Consultee Comment for planning application 23/02713/DISC

Application Number	<input type="text" value="23/02713/DISC"/>
Location	<input type="text" value="OS Parcel 6372 South East Of Milestone Farm Broughton Road Banbury"/>
Proposal	<input type="text" value="Discharge of Conditions 5 (ground levels and finished floor levels), 6 (contamination), 10 (surface water drainage scheme), 11 (means of access (Phase I v Phase II), 12 (Construction Traffic Management Plan), 13 (Travel Information Pack), 15 (northern footpath link), 16 (Construction Environmental Management Plan), 17 (Sustainability/Energy Statement) and 21 (External Lighting Strategy) of 21/03644/OUT"/>
Case Officer	<input type="text" value="Chris Wentworth"/>
Organisation	<input type="text" value="Arboriculture (OCC)"/>
Name	<input type="text"/>
Address	<input type="text"/>
Type of Comment	<input type="text" value="Object"/>
Type	<input type="text"/>
Comments	<p>Application Reference: 23/02713/DISC</p> <p>Location: OS Parcel 6372 South East Of Milestone Farm, Broughton Road, Banbury</p> <p>Comments:</p> <p>These comments are made from reviewing the following plans and reports:</p> <p>Balmoral Avenue, Banbury (Phase 2) Condi

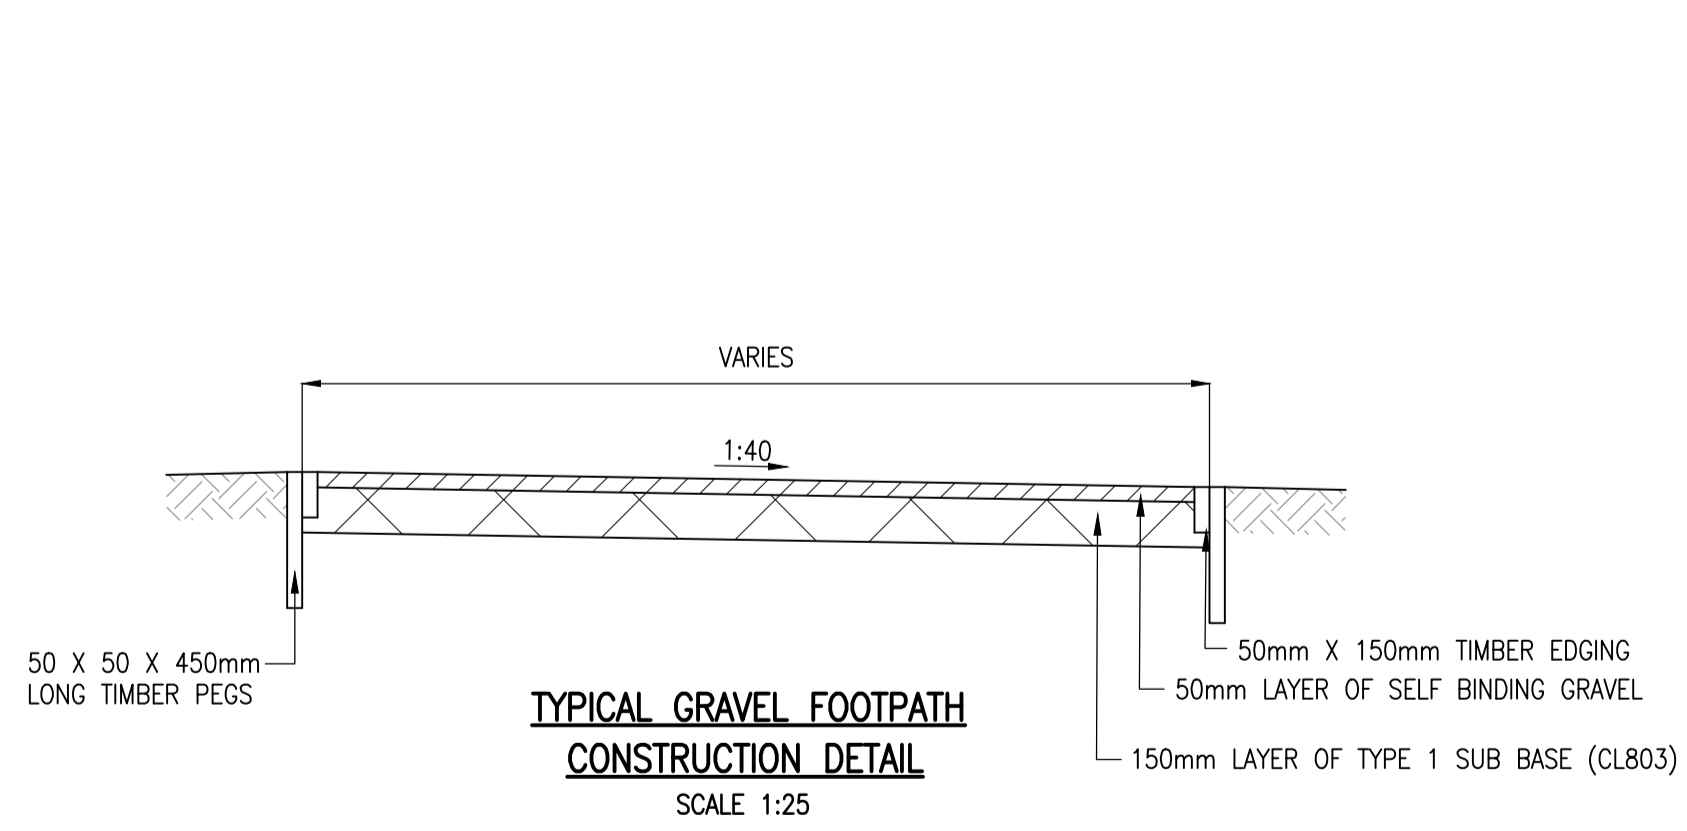
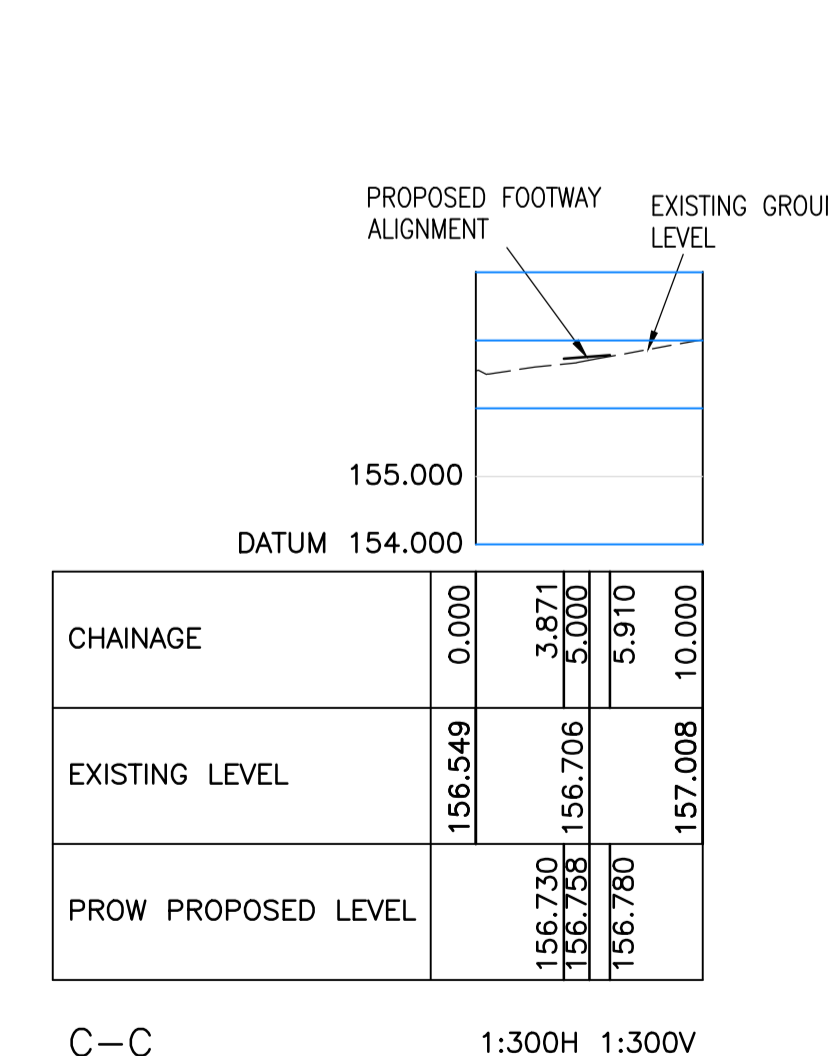
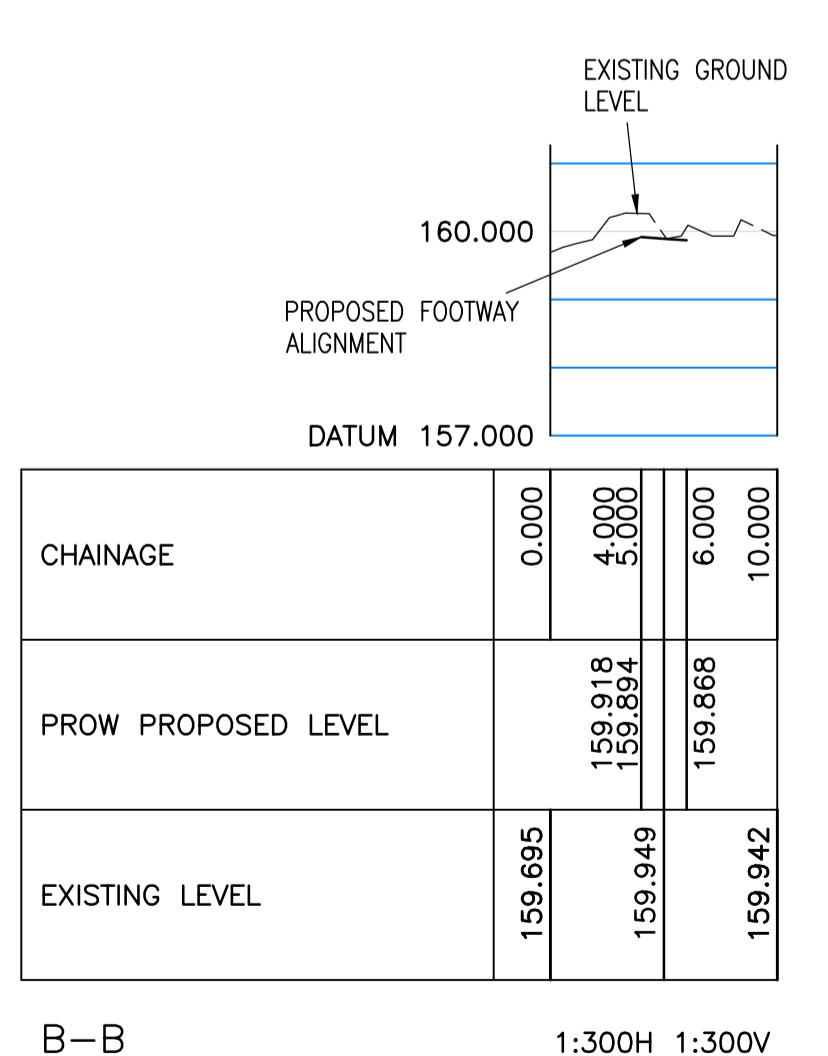
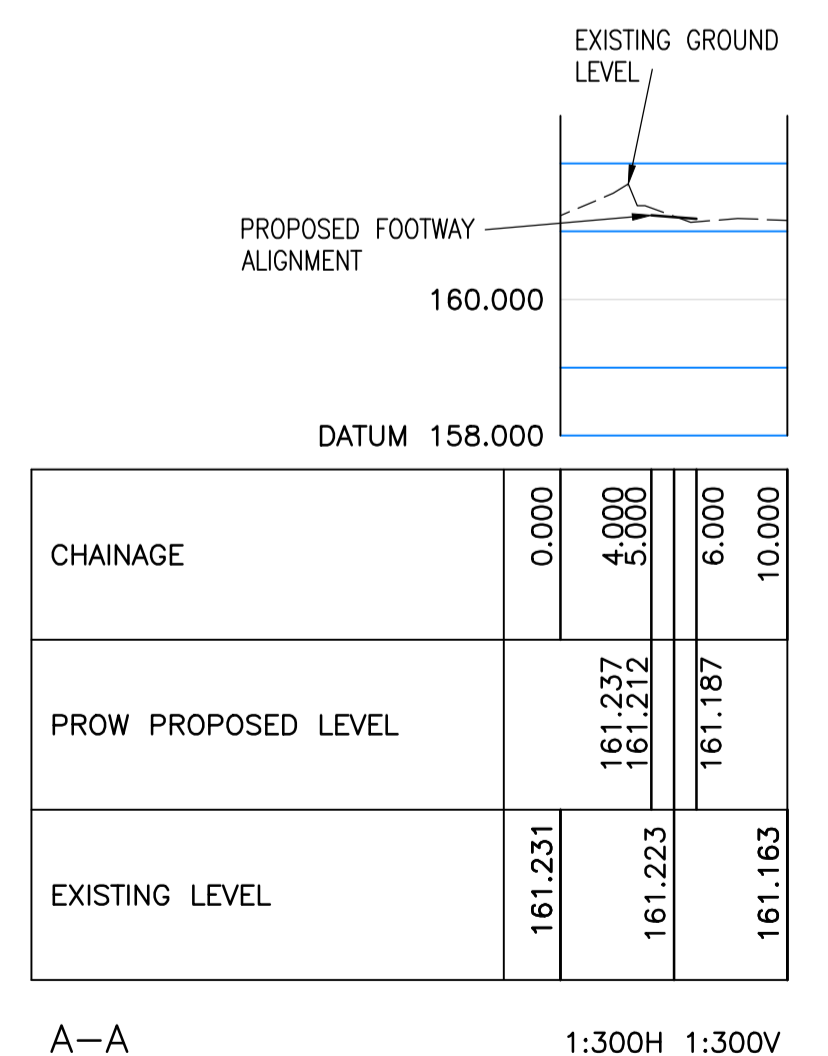
The submitted Prow General Arrangement plan shows a bound gravel footway construction proposed adjacent to the North boundary. The plan also shows cross sections and levels plans that appear to show excavation of the existing levels to construct the proposed path. As shown within the Arboricultural Report submitted with application 21/03644/OUT, a large number of trees are located within this area. Where the works are proposed are within the RPAs of a large number of trees and excavation to construct the path will have significant adverse impacts to these trees and is not acceptable from an arboricultural perspective.

From the information submitted it has not been possible to determine if the existing Public Right of Way is surfaced. Could the path remain as existing, retaining the existing levels? If a surfaced path is required, then an Arboricultural Impact Assessment in accordance with BS 5837:2012 will be required to be completed by an arboriculturist to accurately assess the proposed works and provide details of suitable mitigation. The design will also be required to comply with section 7.4 of BS 5837:2012 and also Arboricultural Association's Guidance Note 12, implementing a No Dig Cellular Confinement System methodology. An Arboricultural Method Statement and Tree Protection Plan will also need to be agreed, setting out adequate tree protection measures and sufficient installation methodology to ensure the protection of the adjacent retained trees.
